Subject: ACU-20-00002 Lockwood  
SR 903 MP 4.59 left

We have reviewed the proposed project and have the following comments.

RECORD OF SURVEY

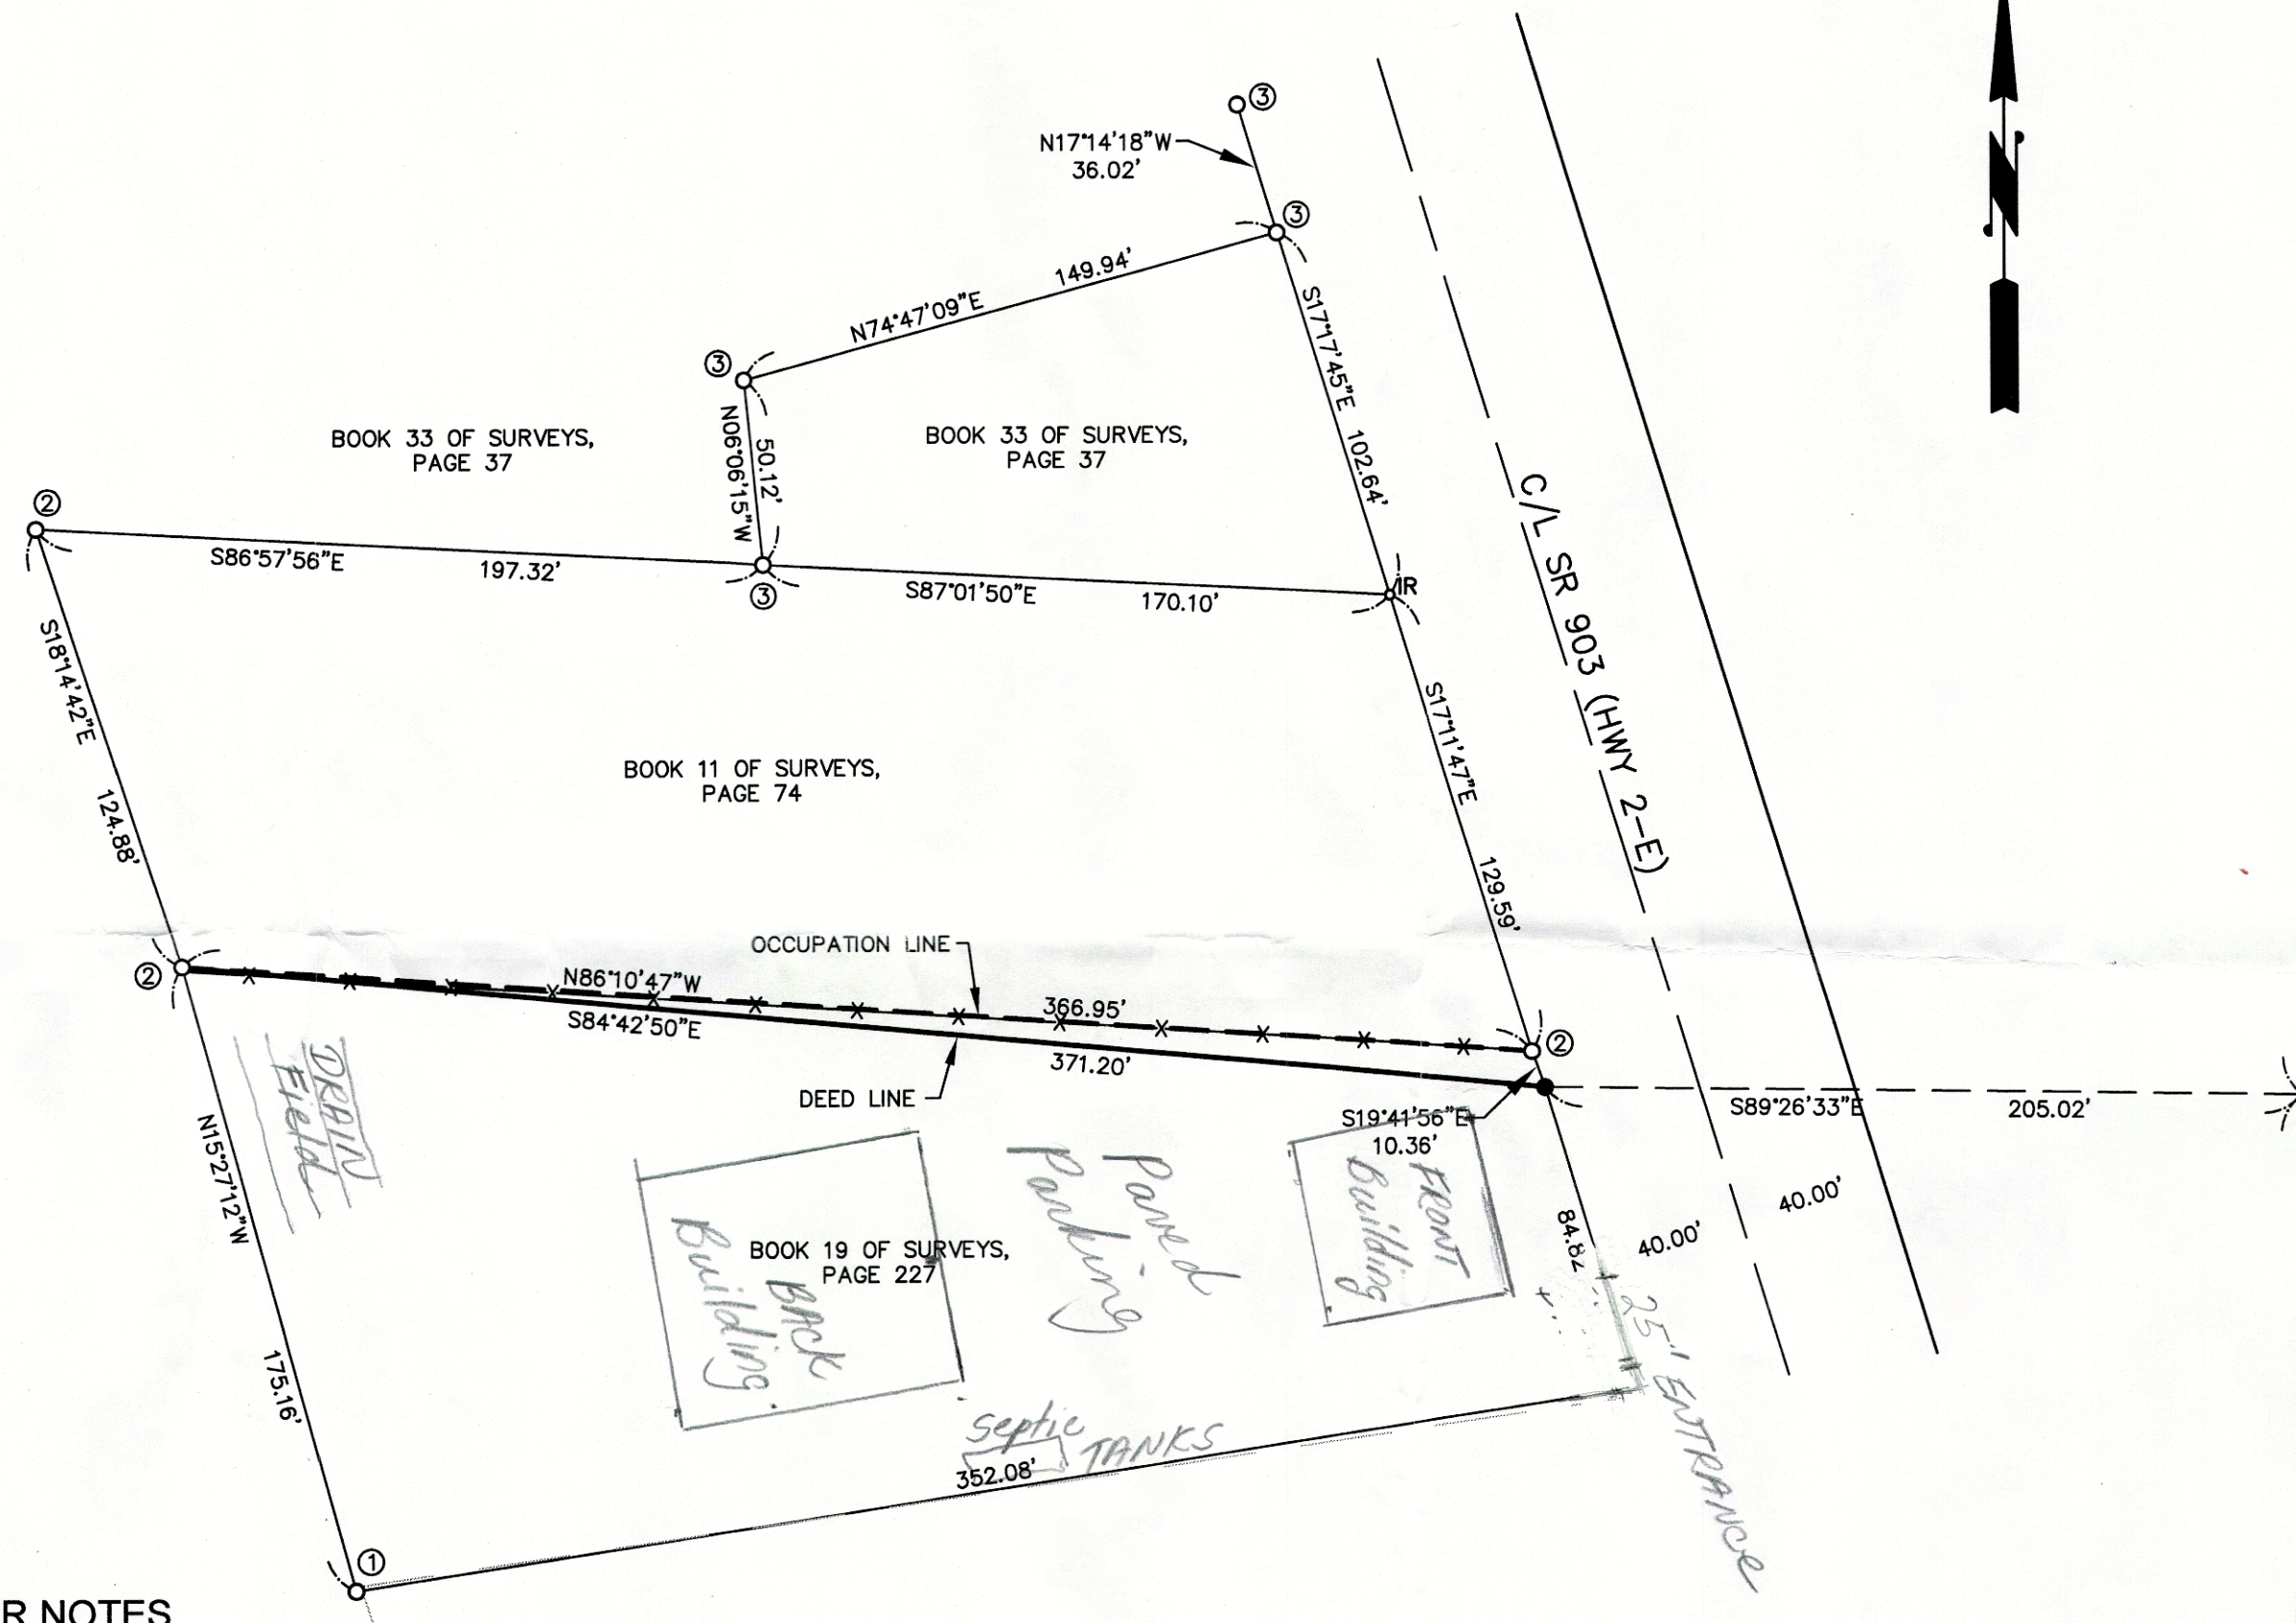
- The subject property is adjacent to the State Route 903 (SR 903). SR 903 is a managed access class 5 highway with a posted speed limit of 35 miles per hour. The parcel currently has a minor access connection to SR 903, not to exceed 100 average weekday vehicle trip ends. No additional access locations will be allowed.

- Any proposed lighting should be directed down towards the site and away from SR 903.
- Stormwater and surface runoff generated by this project must be retained and treated on site. Any discharge onto WSDOT right-of-way will require an approved Utility Permit.

- Any snow accumulated on the property shall not be moved onto WSDOT right-of-way. We encourage the proponent to not underestimate the potential for large volumes of snow and designate a snow storage area on the property.
